NOTICE OF DECISION

Proposal: Erection of a double garage to the front of the dwelling to allow for overnight parking spaces (resubmission of 22/00332/F)

Location: New Rectory, Acre Ditch, Sibford Gower, OX15 5RW

REFUSAL OF PERMISSION FOR DEVELOPMENT

DRAWING:
Plans and Elevations

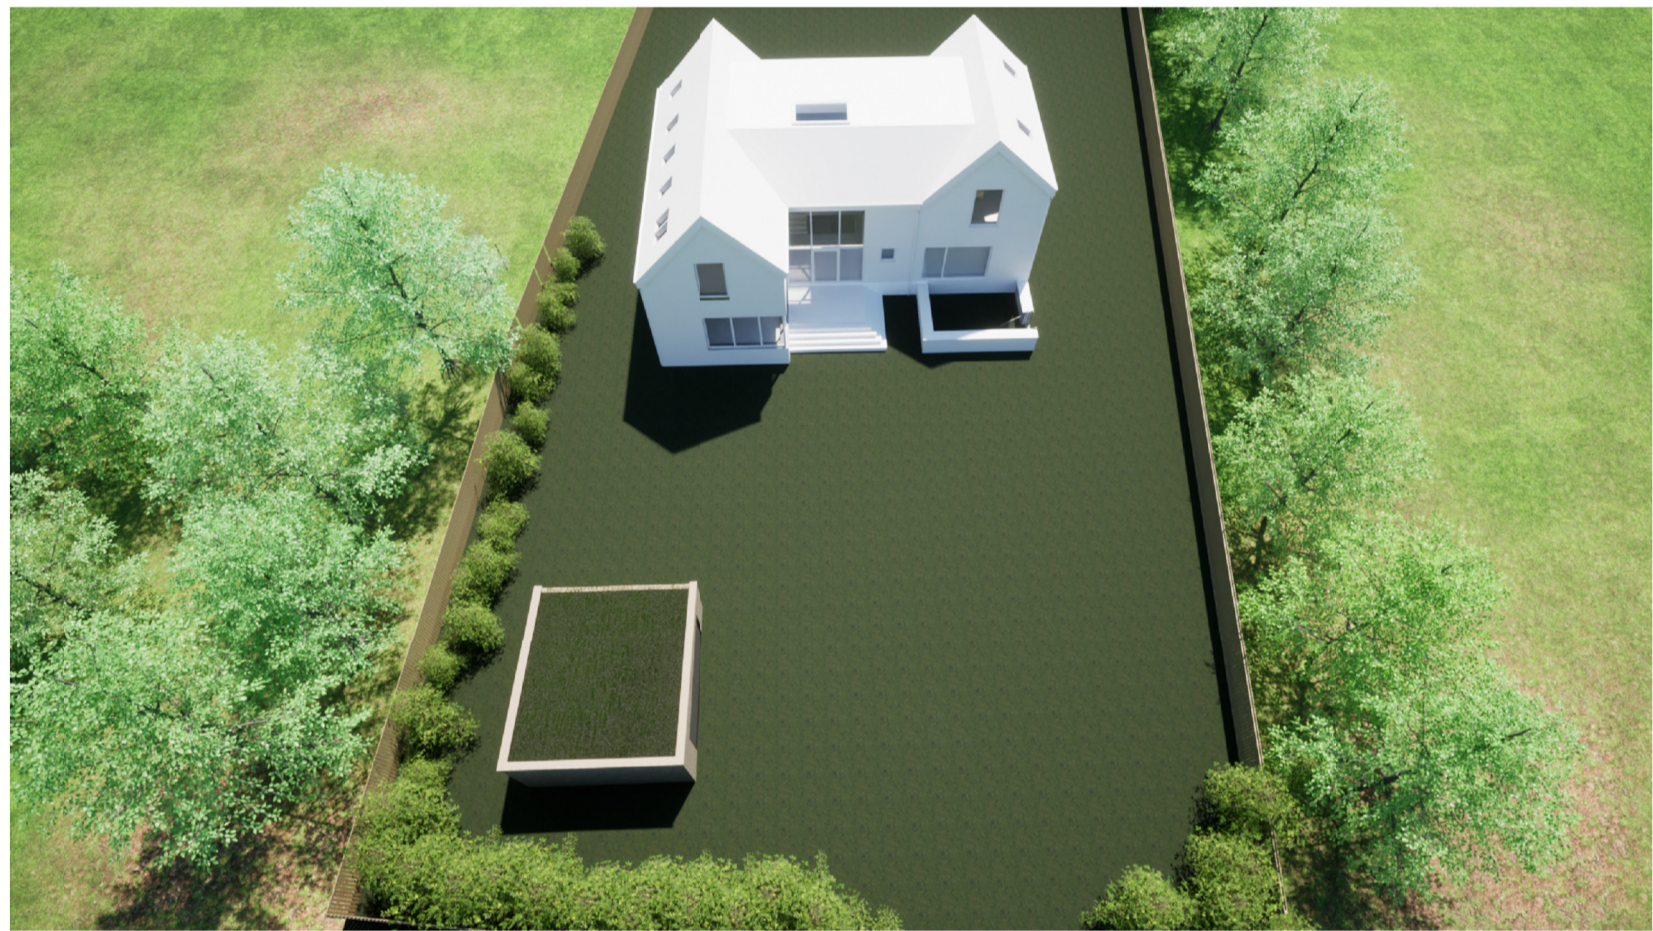
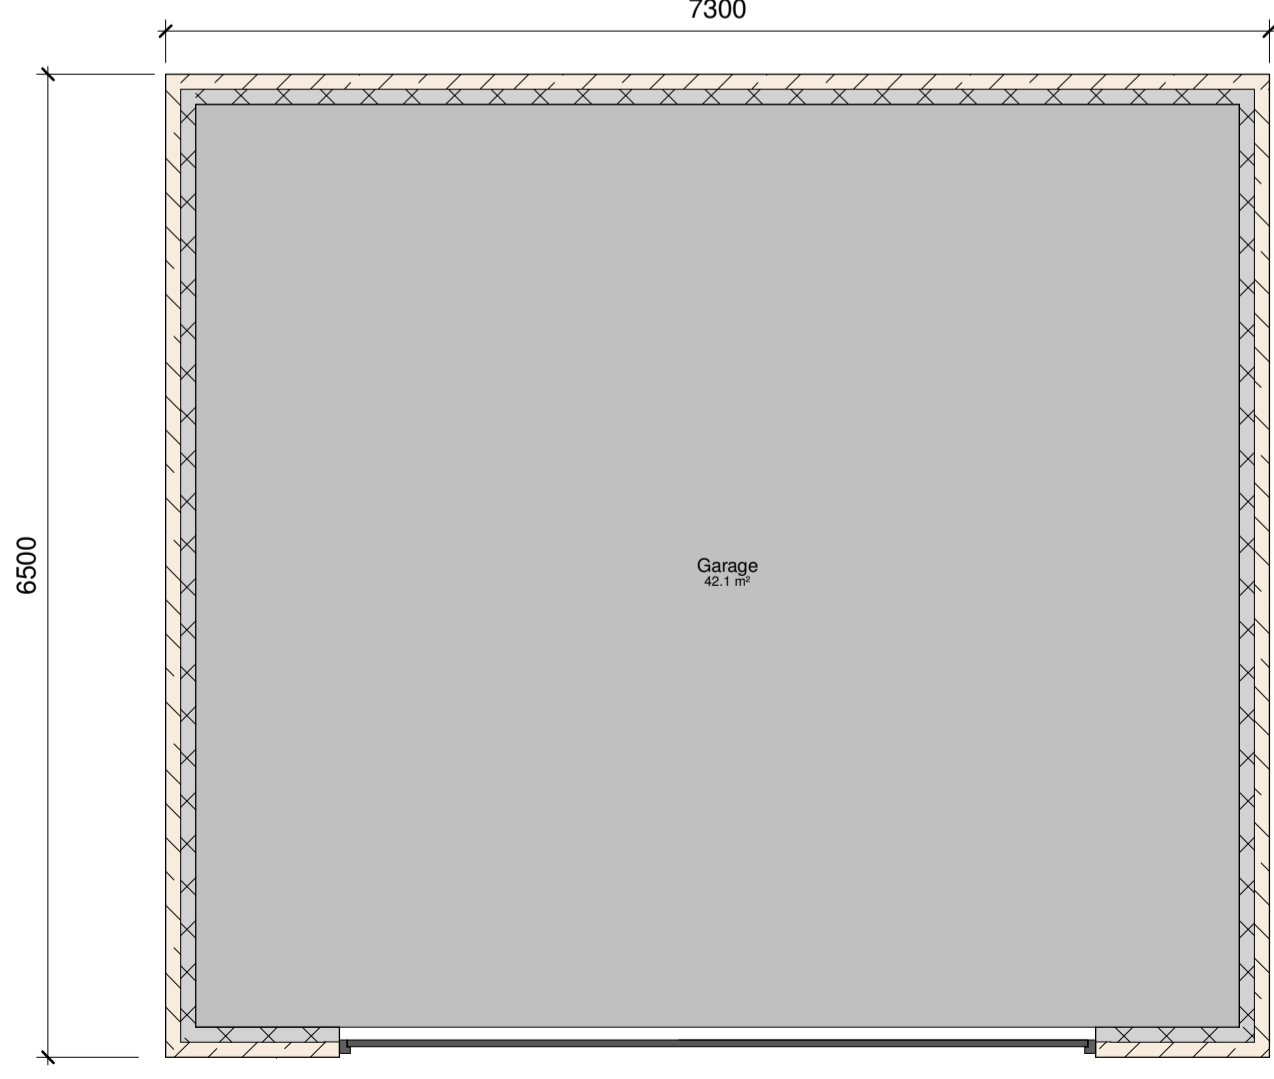
1. By reason of its scale and siting the proposed garage would result in a visually incongruous form of development that would adversely affect the character and appearance of the area and would result in harm to the significance of heritage asset through the change that would occur to its setting. The proposal is therefore contrary to Policy ESD15 of the Cherwell Local Plan 2011-2031 Part 1, saved Policies C28 and C30 of the Cherwell Local Plan 1996 and Government guidance contained within the National Planning Policy Framework.
